WEST SUSSEX COUNTY COUNCIL CONSULTATION

TO:	Arun District Council FAO: Amber Willard
FROM:	WSCC – Highway Authority
DATE:	23 February 2026
LOCATION:	The Croft Surgery Barnham Road Eastergate PO20 3RP
SUBJECT:	BN/130/25/PL Change of use of the existing building and associated facilities from a doctor surgery (Use Class E) to a place of worship (Use Class F) and all associated works and infrastructure. This application is in CIL Zone 2 (Zero Rated) as other development. amendment to the above application dated 9th February 2026 relating to:- Response to WSCC highway queries - 13/02/2026
DATE OF SITE VISIT:	n/a (desktop study undertaken)
RECOMMENDATION:	Advice

Proposed Ground Floor Plan

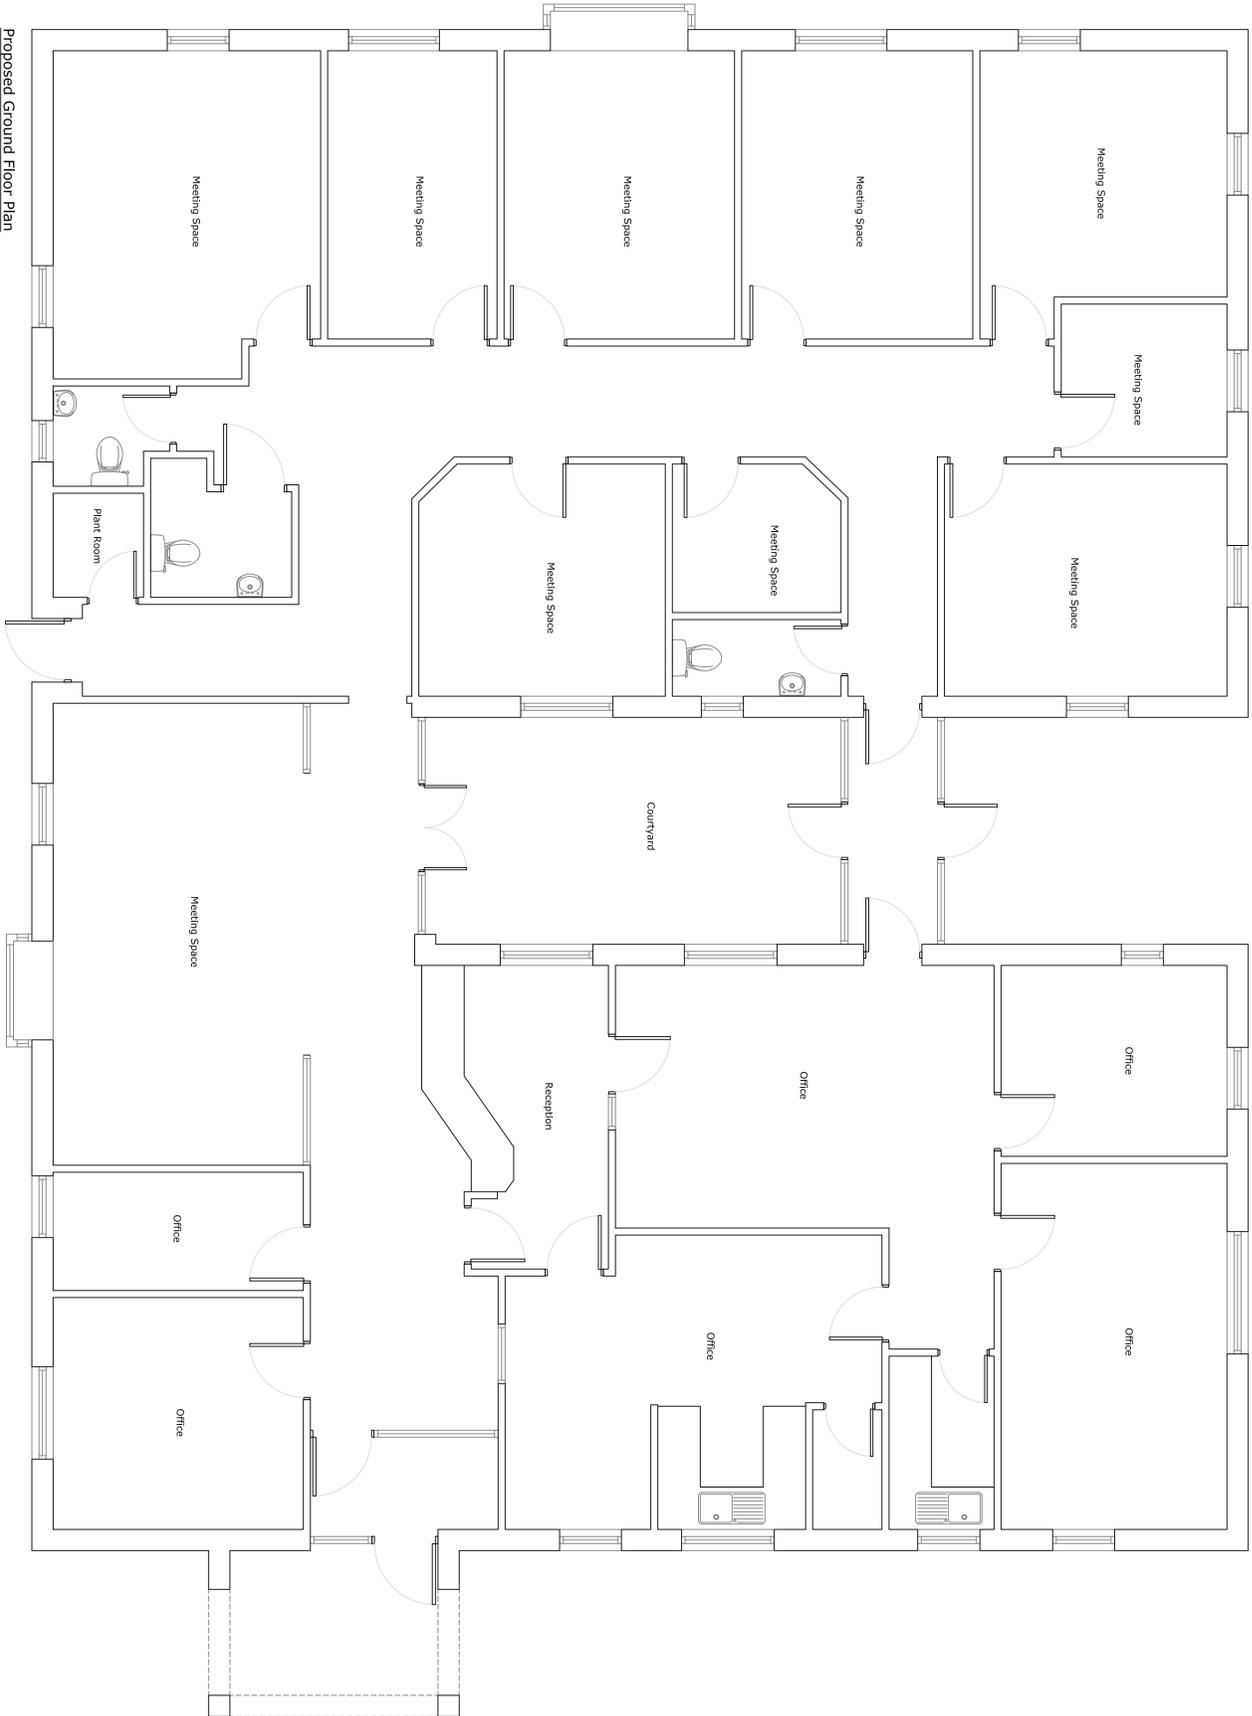
1. The floor plans show a large number of rooms within the building, previously used as either consulting rooms or small meeting rooms when the building was in use as a doctor's surgery. As such, there does not appear to be a main worship area which is traditionally associated with church buildings. Applicants to explain how the building will be used for their purposes, including numbers of parishioners expected to be on site at any one time.

In response to questions 1 and 2, the principal meeting and worship area for the proposed use will be the former GP surgery waiting room. The smaller former consulting rooms will be used only for ancillary purposes, including administration, private pastoral meetings between members of the congregation, and storage. These rooms will not function as separate activity areas or support any form of multi-use community operation in addition to the twice per week congregation. The expected attendance remains as set out in the Planning Statement and as follows: a maximum congregation of 30–40 individuals attending only twice per week (Monday evenings and Sunday mornings). This compares as follows to the former GP use, which regularly accommodated 45–50 people at peak times at full room capacity throughout the full working day. The proposal therefore represents a clear and demonstrable de-intensification of use and will generate significantly fewer trips than the historic established use.

The above comments are noted. Clearly, from reading the reply, the proposed occupier has bespoke requirements regarding worship requirements. On the basis that it is as proposed – both in terms of numbers of parishioners and times that the building would be used – then the Highway Authority would not wish to raise objection to this. If appropriate, the case officer might wish to consider attaching a bespoke/personal planning consent to manage this to the levels proposed.

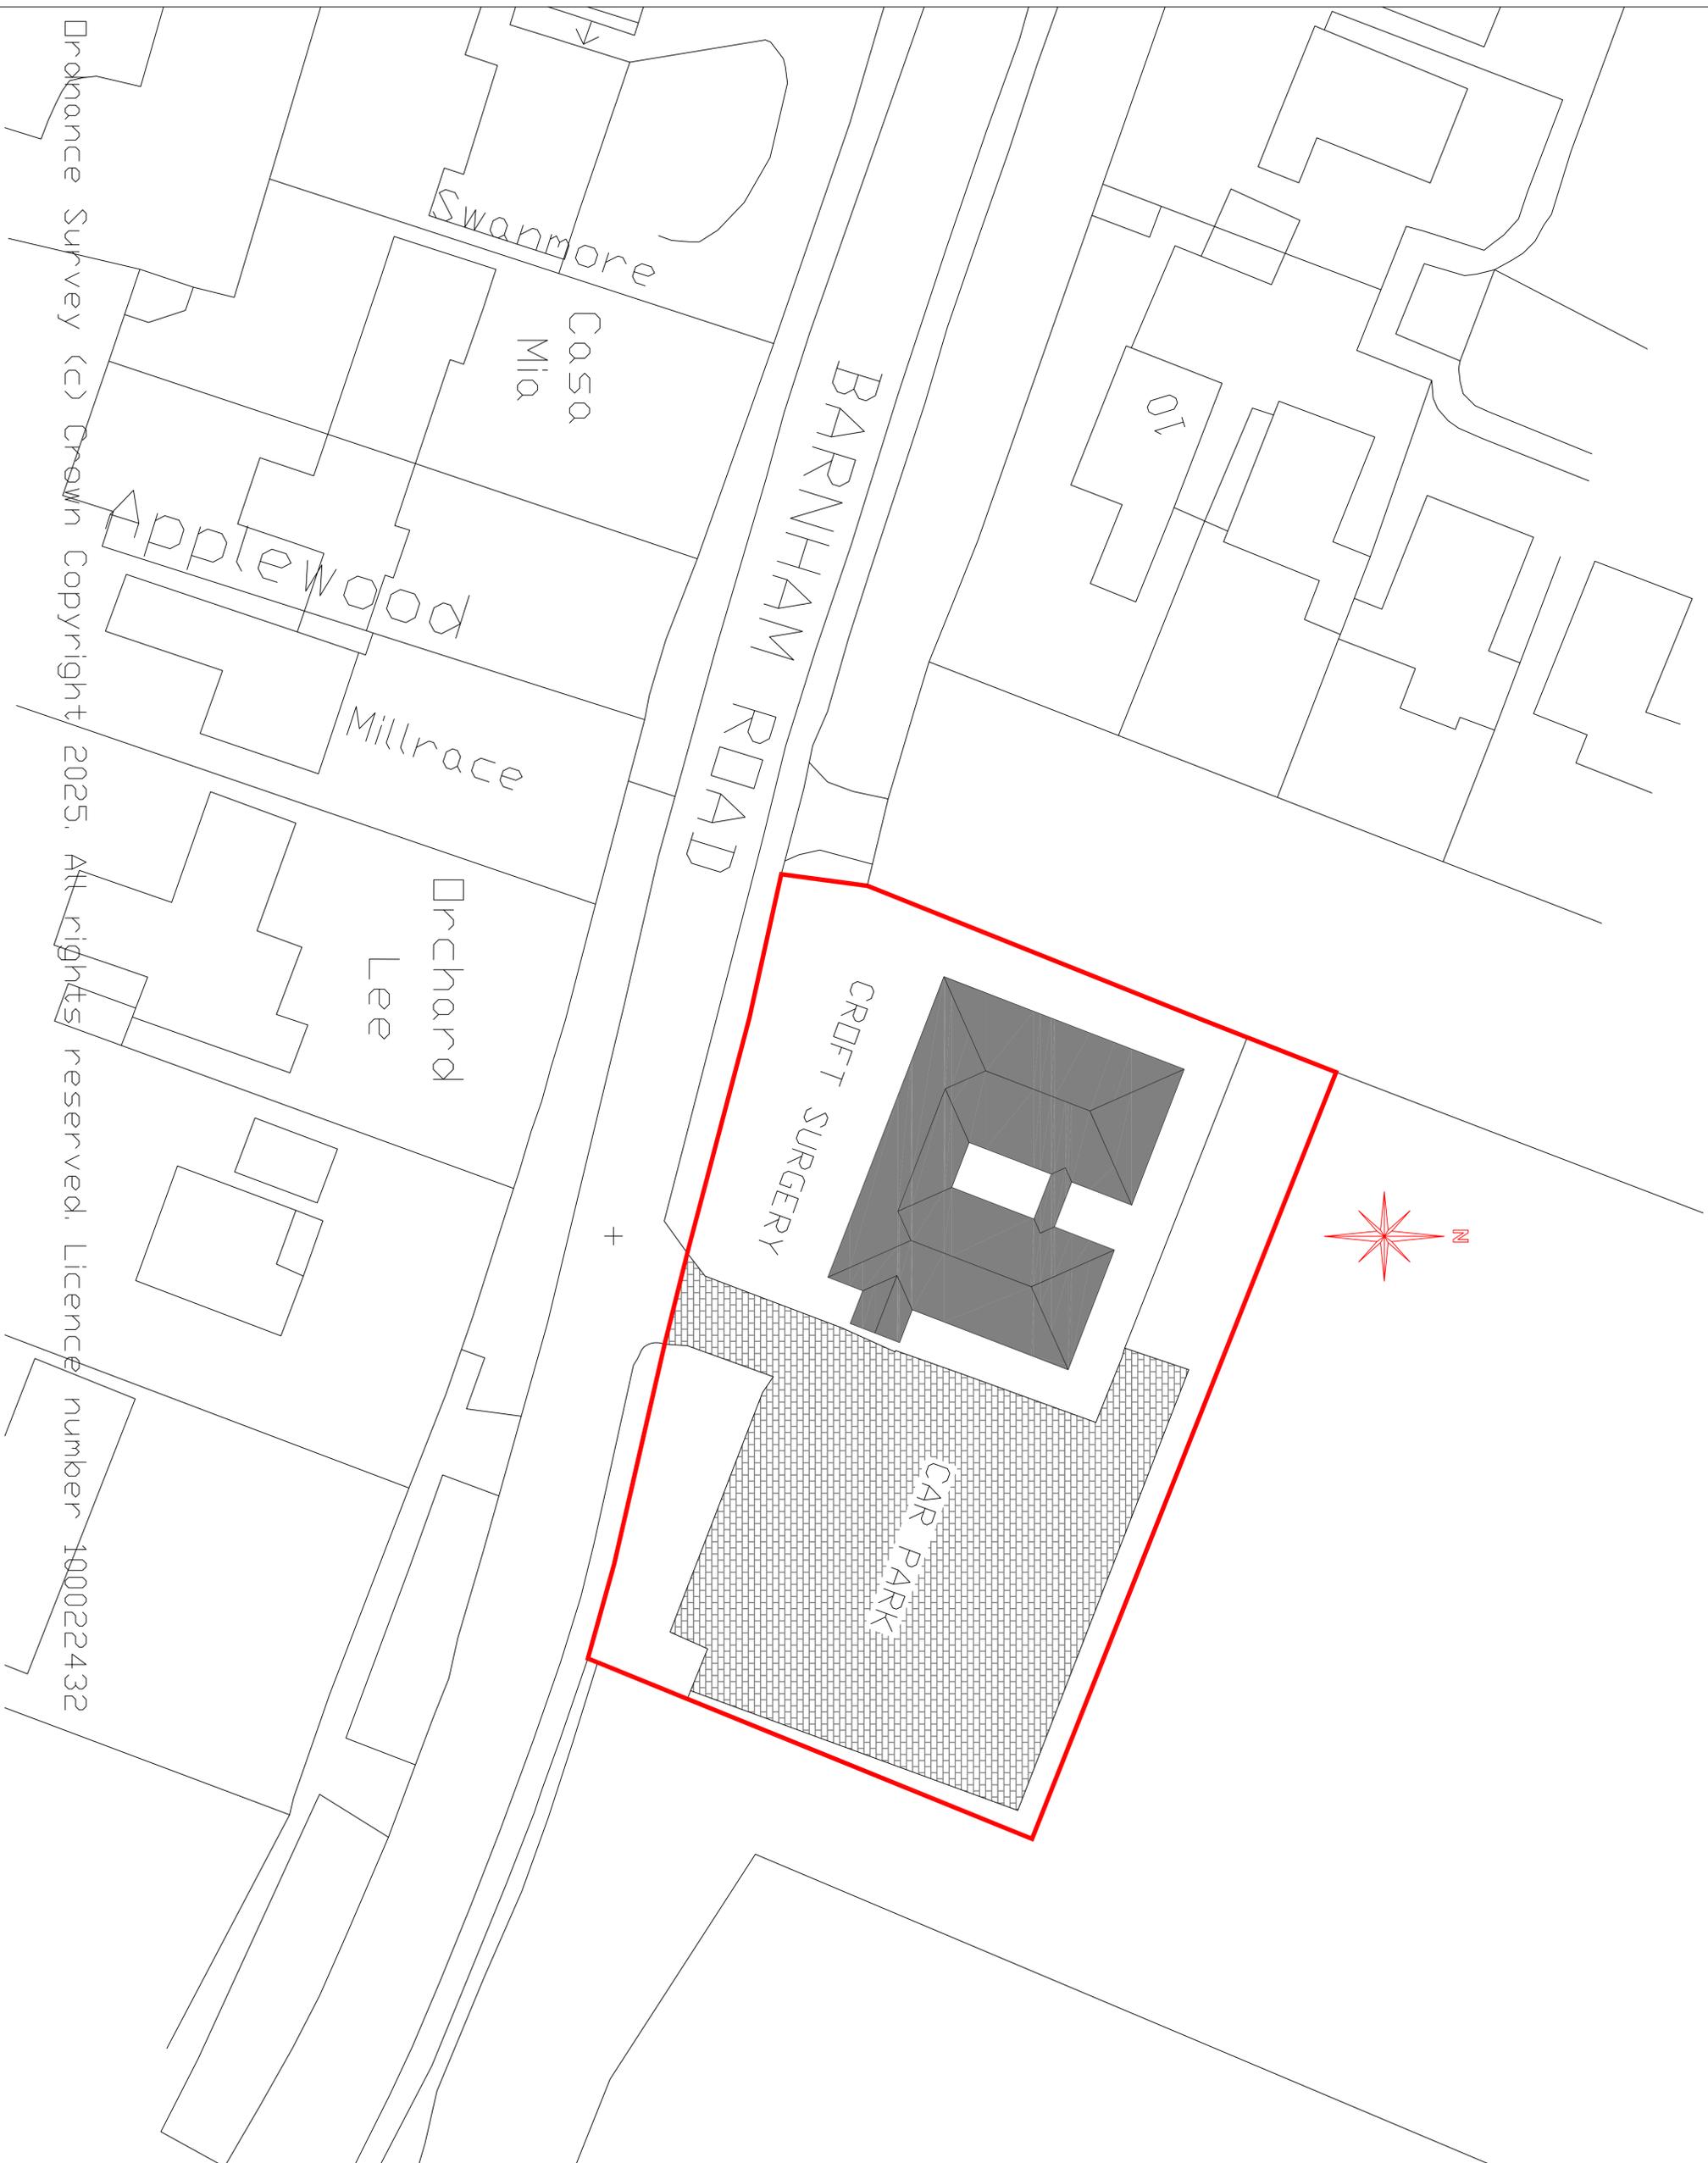
*The above comments are noted. While overall activity might decrease from previous levels should planning consent be granted, the promotion of suitable infrastructure in the form of a path from Barnham Road into the site would still, in the Highway Authority's opinion, be a worthwhile addition to encourage access by those parishioners and visitors arriving and leaving on-foot. As such, it is recommended that such a path be constructed at the applicant's expense and be secured by an appropriate planning condition. Mindful of the applicant's concern having a pre-commencement condition attached to any consent, it is therefore recommended that such a path be constructed within **six** months of first occupation to avoid this, with plans submitted to the LPA (and, in turn, the Highway Authority for consideration and approval) within **three** months of first occupation.*

Within **three** months from first occupation of the development, the applicant shall submit to the LPA and CHA for approval, plans showing details of a footpath taken from Barnham Road running alongside the eastern side of the existing vehicular access serving the development. Once approved, the footpath shall thereafter be constructed in accordance with the approved plans within **six** months from first occupation of the development.
